**KIRKLEES METROPOLITAN COUNCIL
INVESTMENT & REGENERATION SERVICE**

DELEGATED DECISION TO DETERMINE PLANNING APPLICATIONS

Reference No:	2025/62/91016/W
Site Address:	Fox House Farm, Moor Lane, Netherthong, Holmfirth, HD9 3UP
Description:	Installation of ground mounted solar panels (Listed Building)
Recommending Officer:	Molly Storer

DECISION – CONDITIONAL FULL PERMISSION

Drg. no.	Rev.
283-24-PL01	B

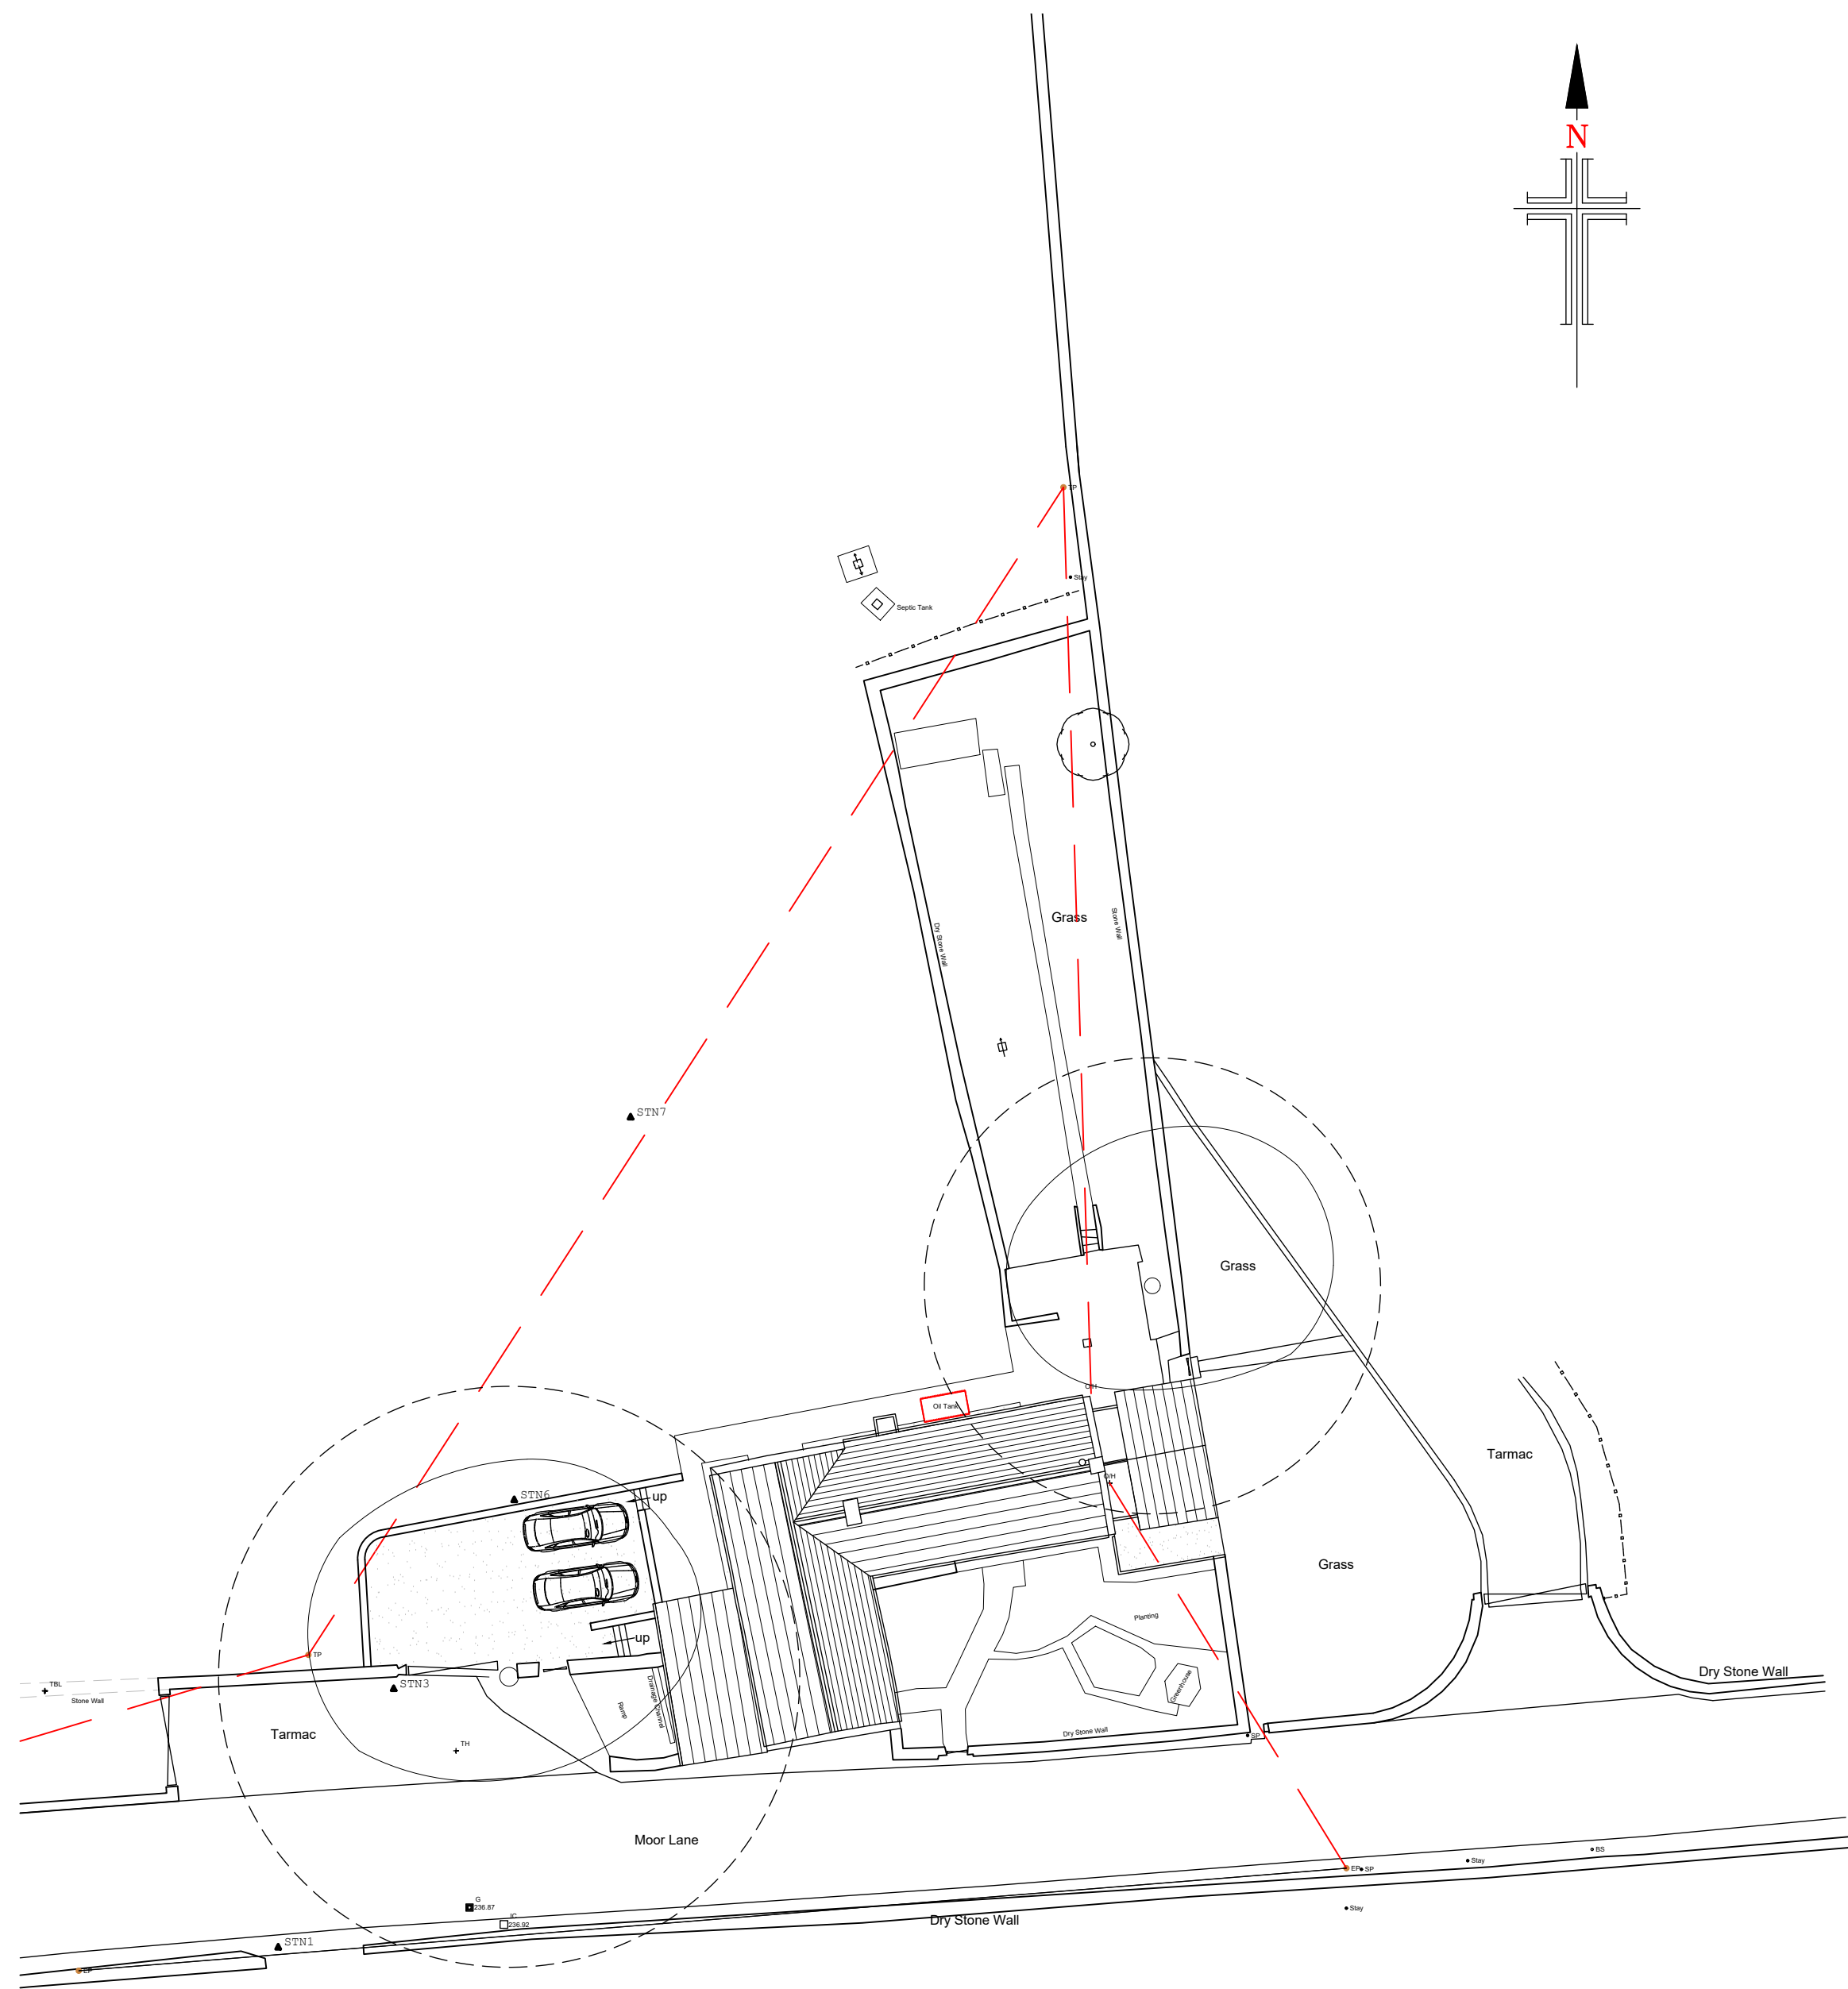
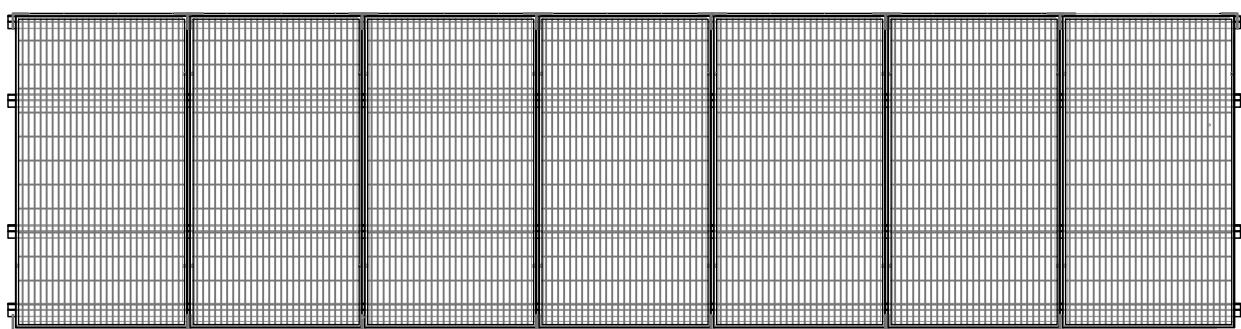
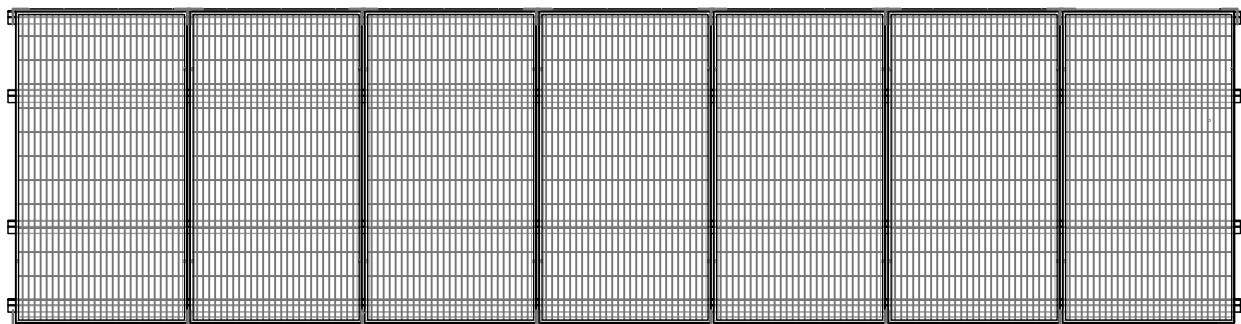
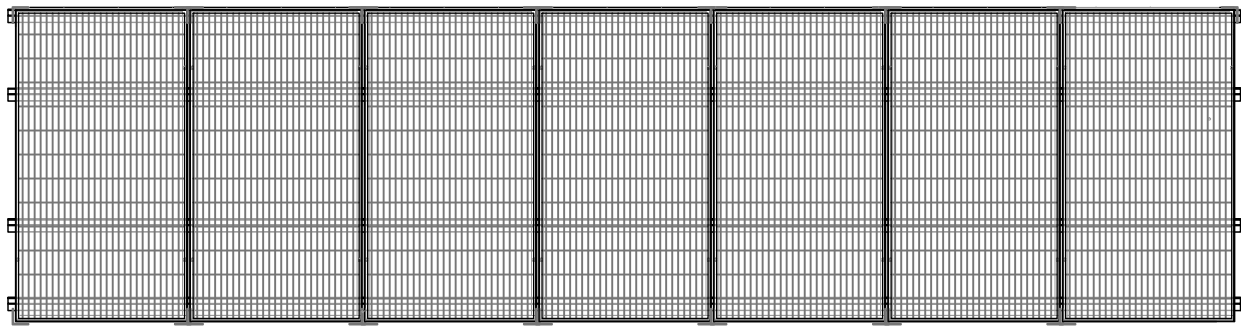
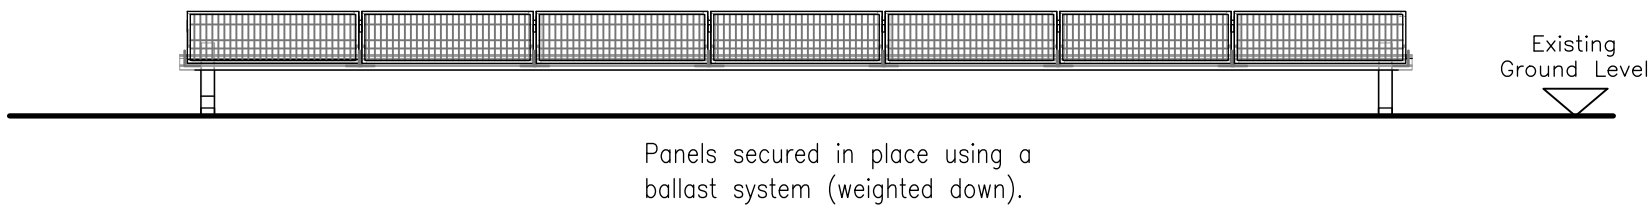
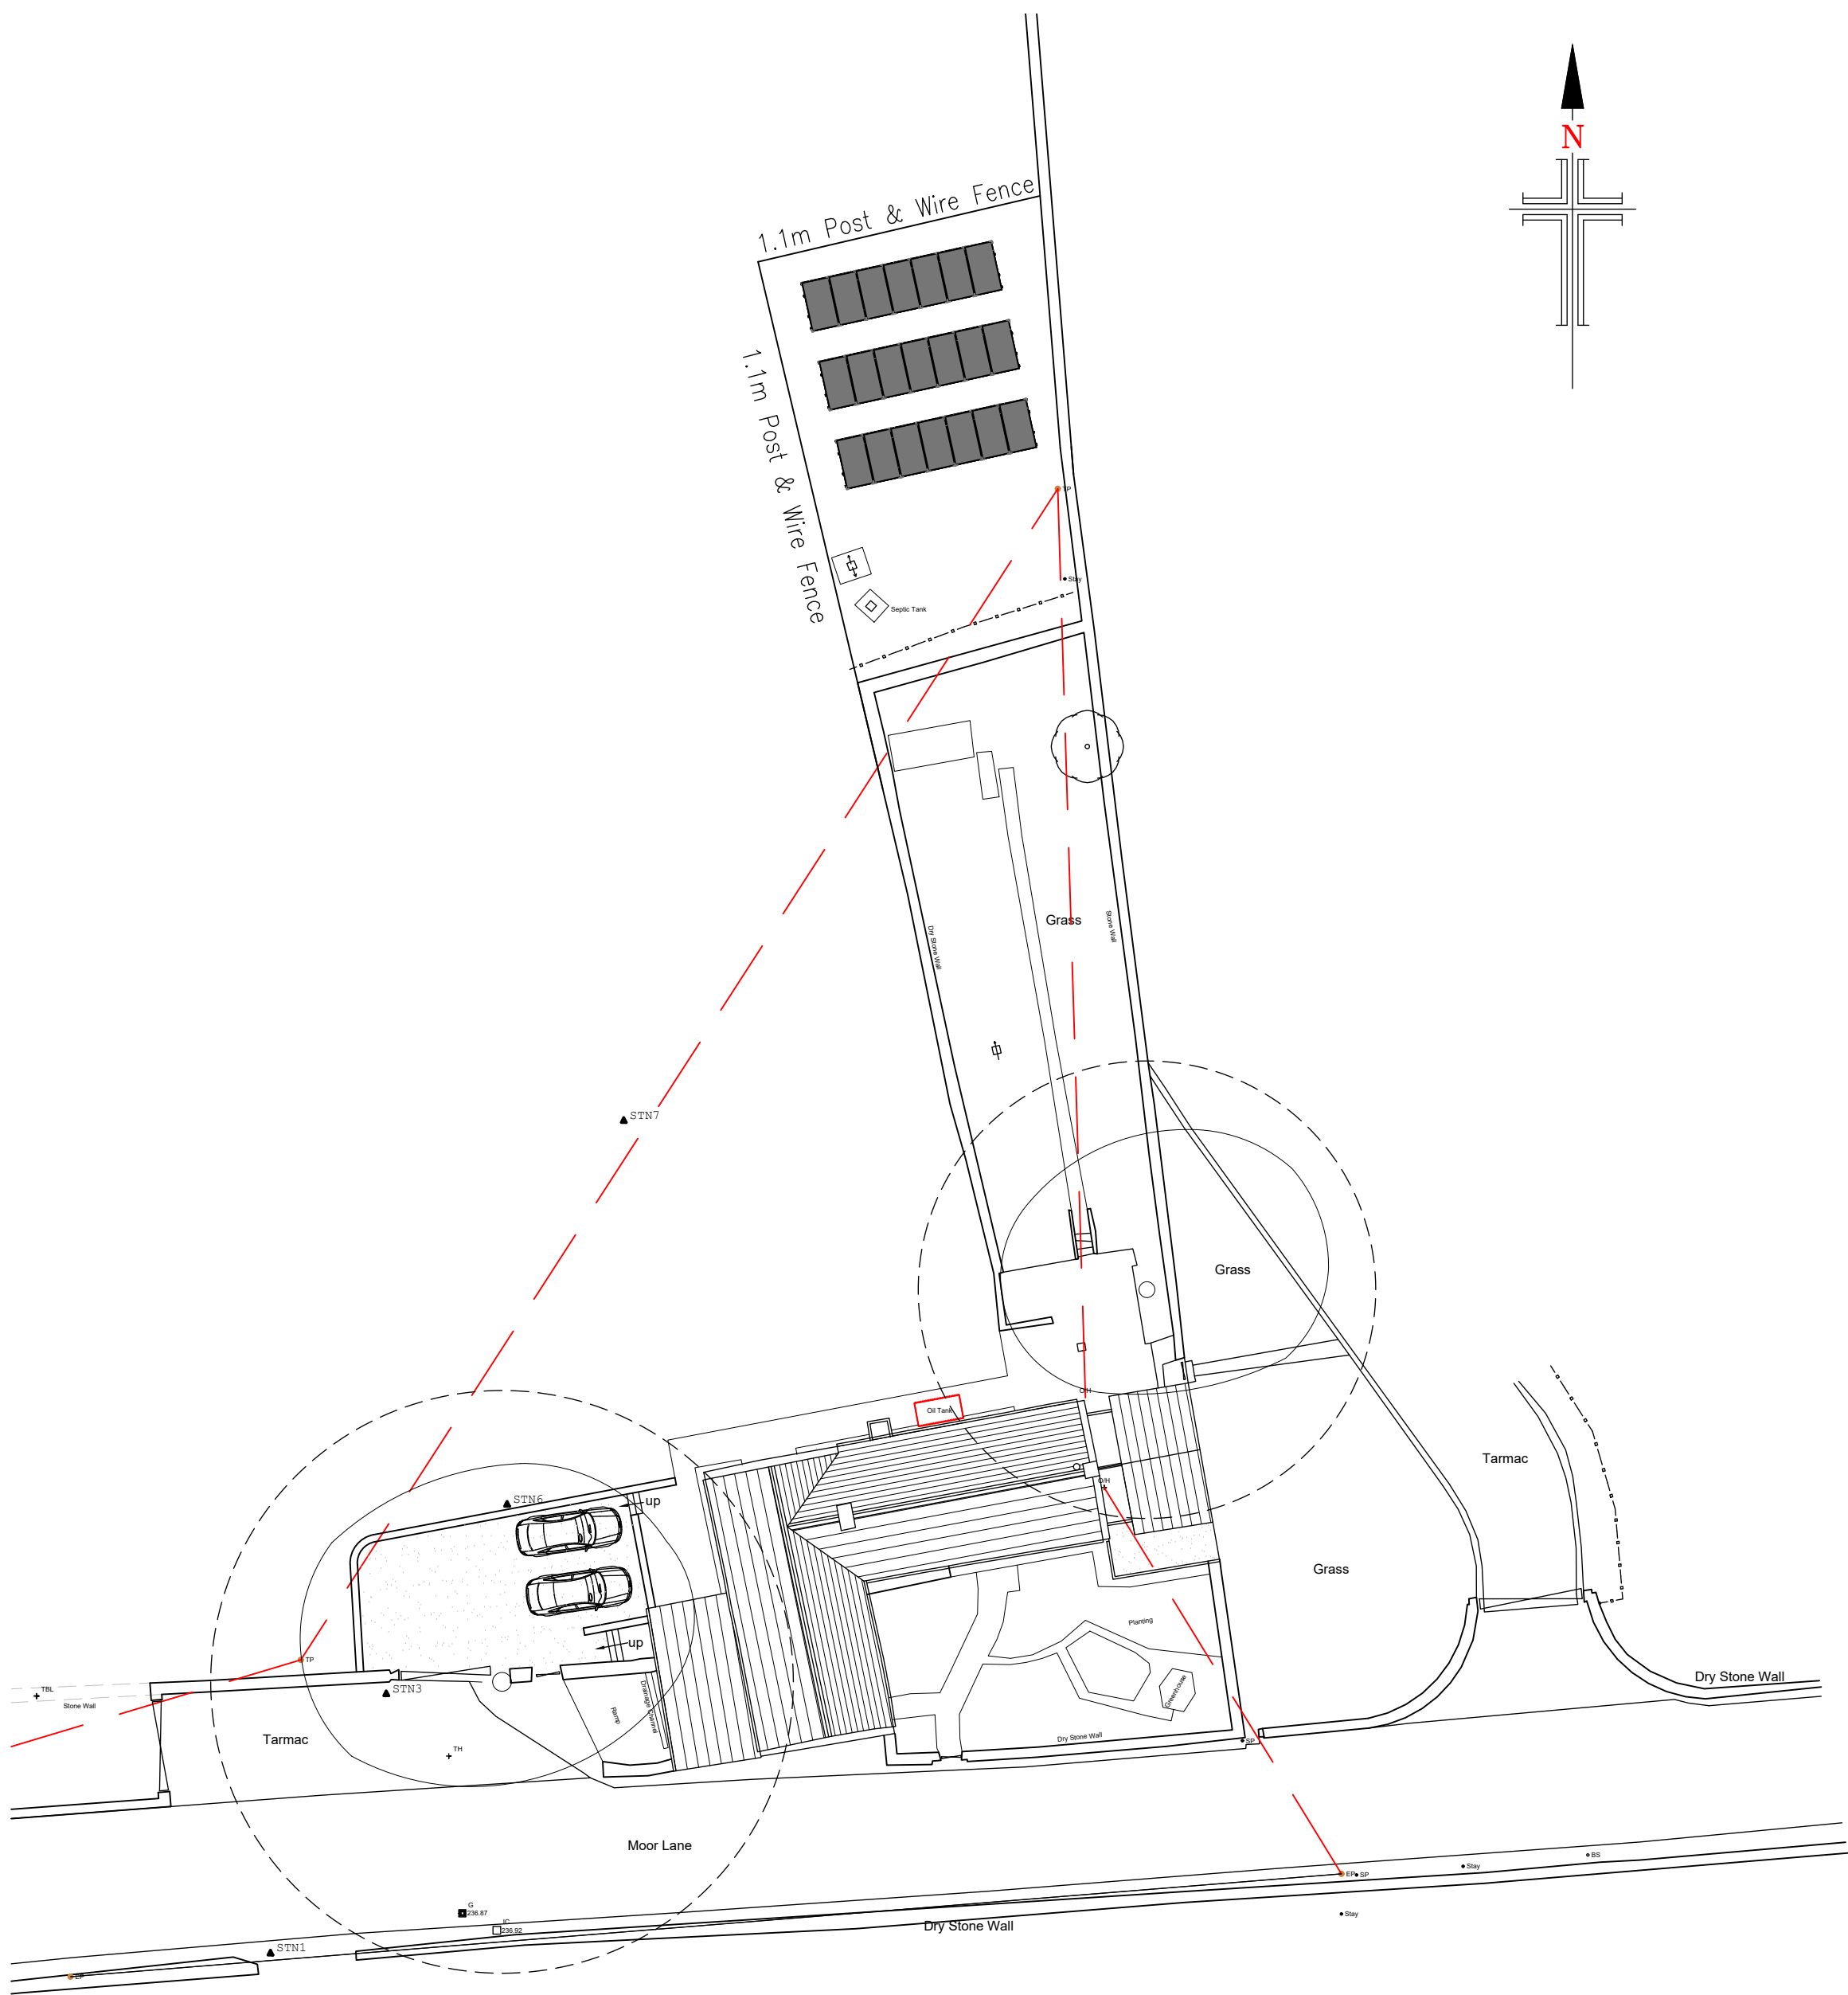
The agent was contacted following discussions with conservation officers. It was noted that the plans state there will be a wire fence surrounding the solar panels however officers suggested that instead a low native hedge surrounds the panels in order to protect the character of the setting of the Listed Building. The agent agreed to this. It was also suggested that conditions be attached to any grant of permission to ensure that the solar panels are to be constructed using black glass and black frames. The agent also agreed to this.

KC Conservation & Design – Recommended that a low native hedge surrounds the panels in order to protect the character of the setting of the Listed Building rather than the wire fence originally proposed. It was also suggested that conditions be attached to any grant of permission to ensure that the solar panels are to be constructed using black glass and black frames.
